Recommendation Report for Planning Permission for Works or Extension to a Dwelling

REF NO: AL/12/19/HH

LOCATION: Fairview
Nyton Road
Aldingbourne
Chichester

PROPOSAL: Rear extension and full loft conversion with dormer window

PROPOSED REAR EXTENSION & LOFT CONVERSION WITH DORMER WINDOW
FAIRVIEW, NYTON ROAD, ALDINGBOURNE, CHICHESTER, WEST SUSSEX, PO20 3UA

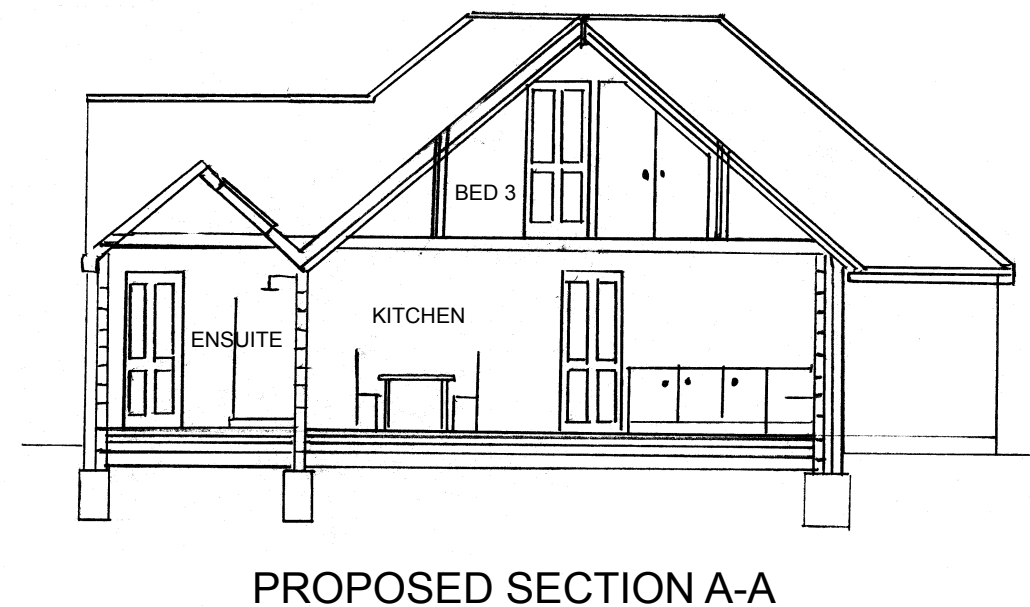
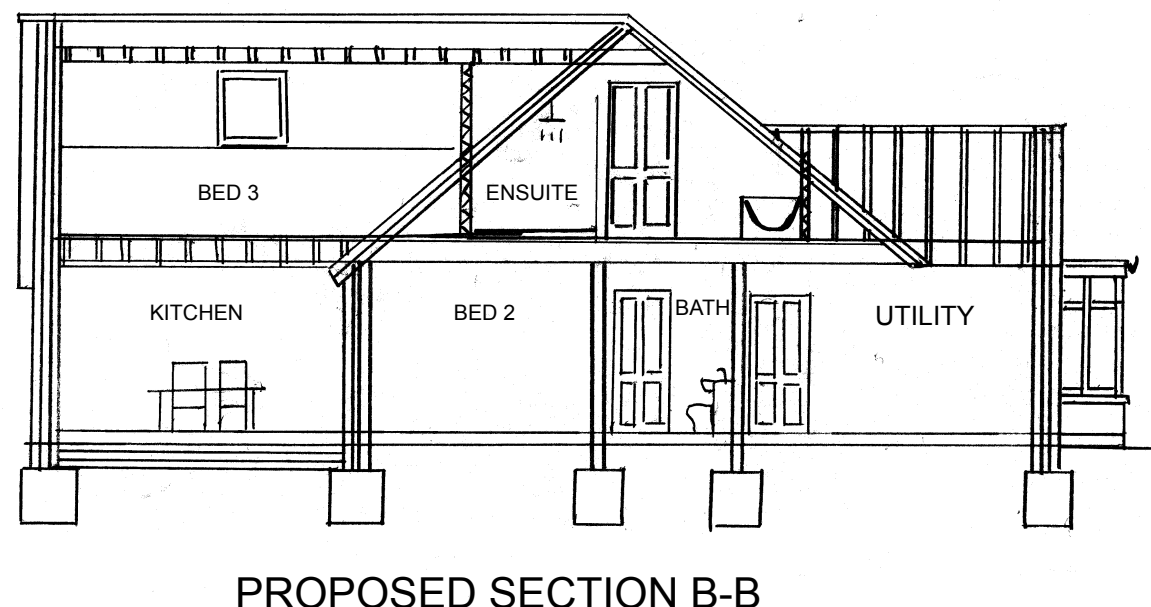
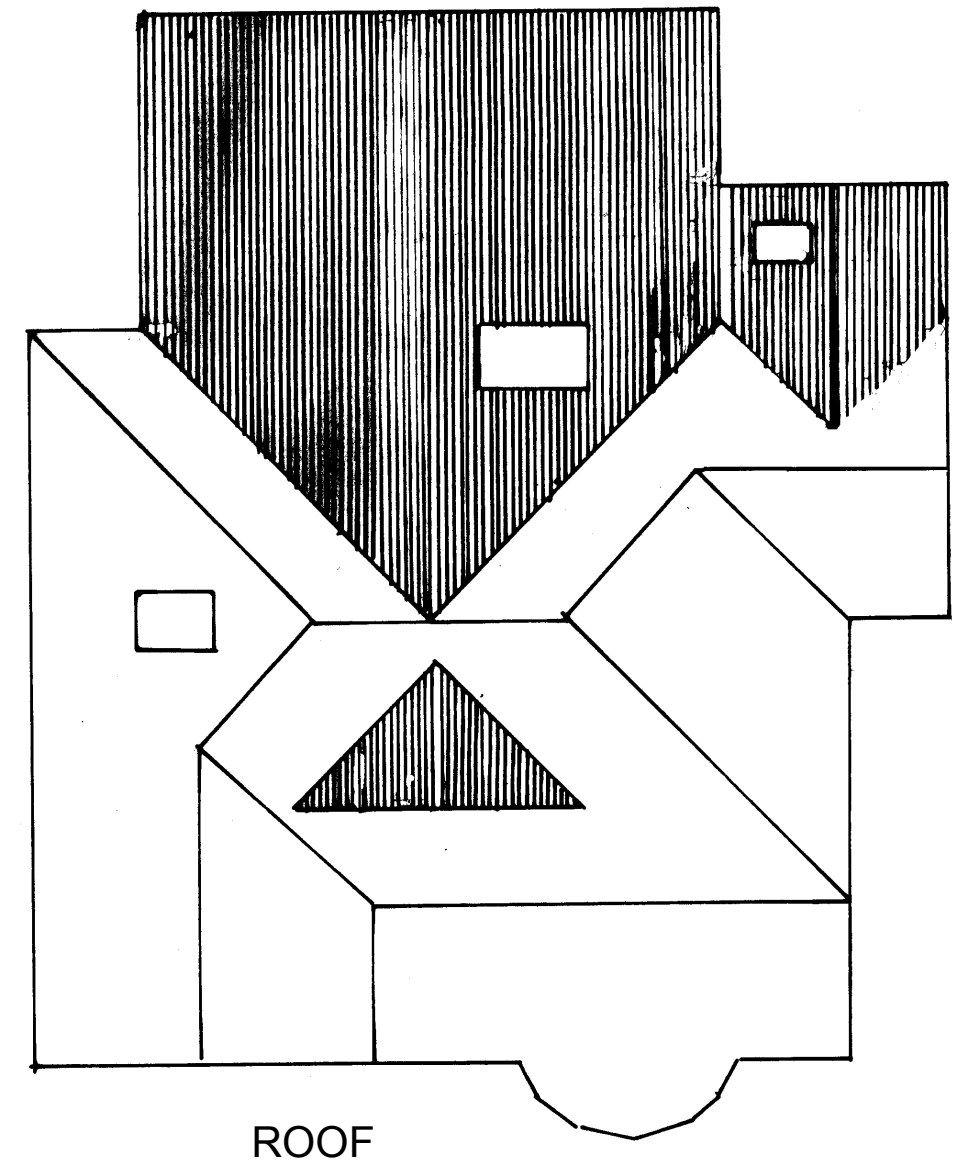
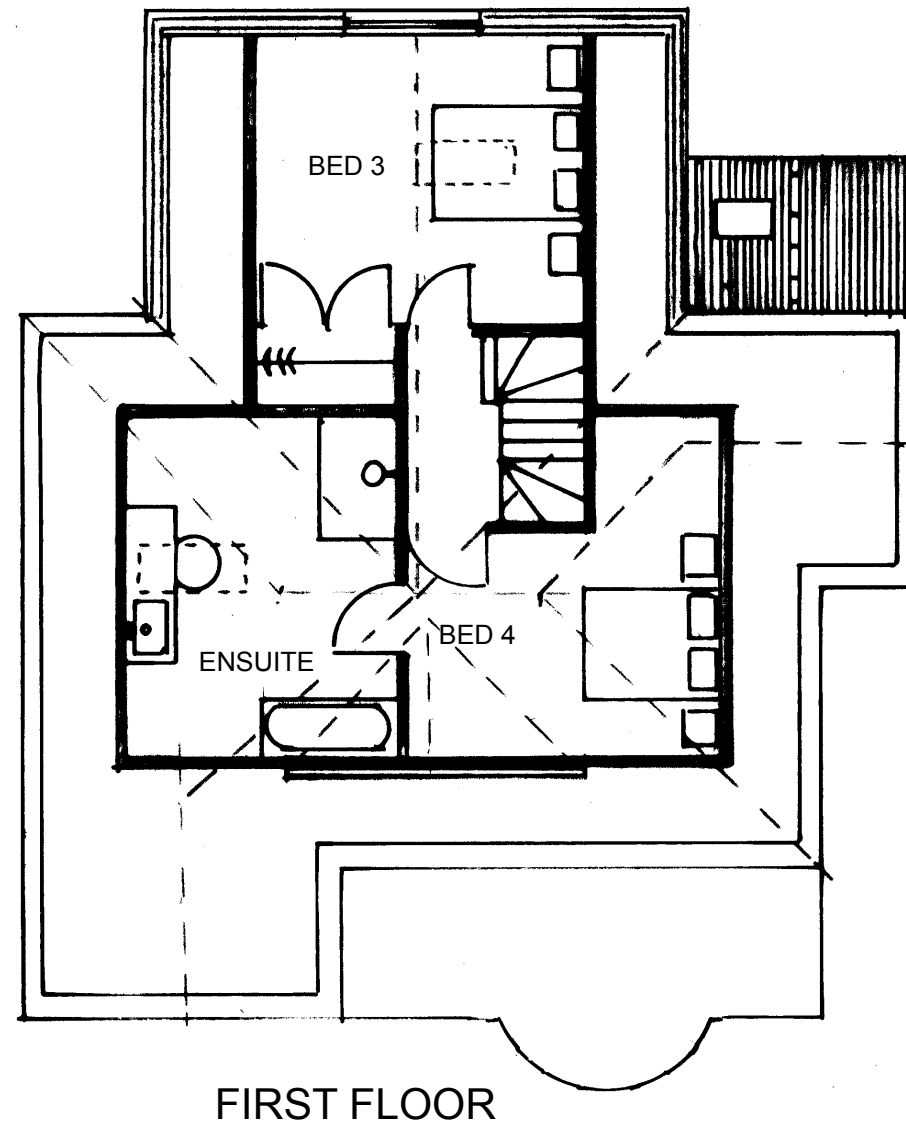
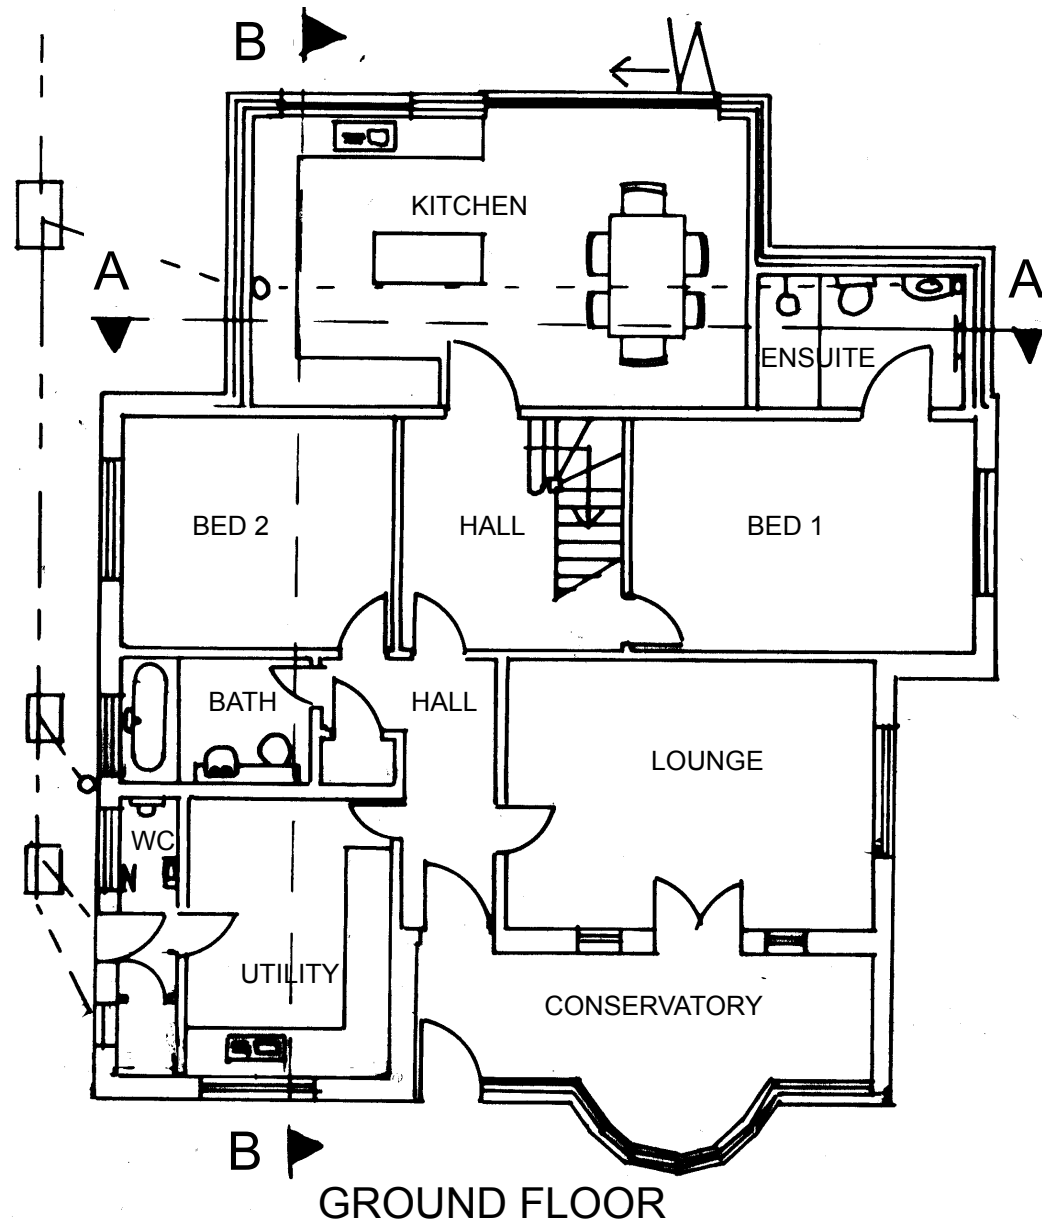
The proposal seeks to construct a dormer window to the front elevation of the dwelling and therefore the development is visible from the street scene. There is however sufficient hedging to the front of the property and therefore the view is largely restricted.

The proposal appear subservient to the host dwelling. The dormer is modest in size and does not appear unduly dominant upon the front elevation. The surrounding properties are of a varied design and style and as such the alteration will not result in the property appearing out of character the area. Grey Cedral cladding is proposed however there is already cladding to the front elevation and again it is not considered to significantly impact the appearance of the dwelling in the area.

The proposal will construct an extension to the rear of the property at both single and two storey height. The two storey part of the development will extend to a depth of approximately 4.2m and run along the rear elevation for 7.2 m. The depth will then reduce to 2.2m with a maximum height of 3.6m.

The two storey extension will have gable roof to match the height of the existing dwelling and this therefore adds bulk to the rear of the property. The property however retains 6.5m to the west and 2.3m to the east. This is considered sufficient distance in which any overbearing or overshadowing is not considered significant. The proposal also does not extend beyond that of the neighbouring dwelling to the north west.

Additional doors and windows to the rear are at a single storey level and not considered to give rise to any adverse overlooking additional to that which is already possible. There will 1 additional window to the rear first floor extension however due to its siting and with 23m to the rear, it is not considered to give rise to any adverse overlooking upon side or rear neighbouring properties. There will be a velux to the south east elevation at first floor level and to the single storey addition however again due to the siting and separation, it is not considered to give rise to any adverse overlooking.
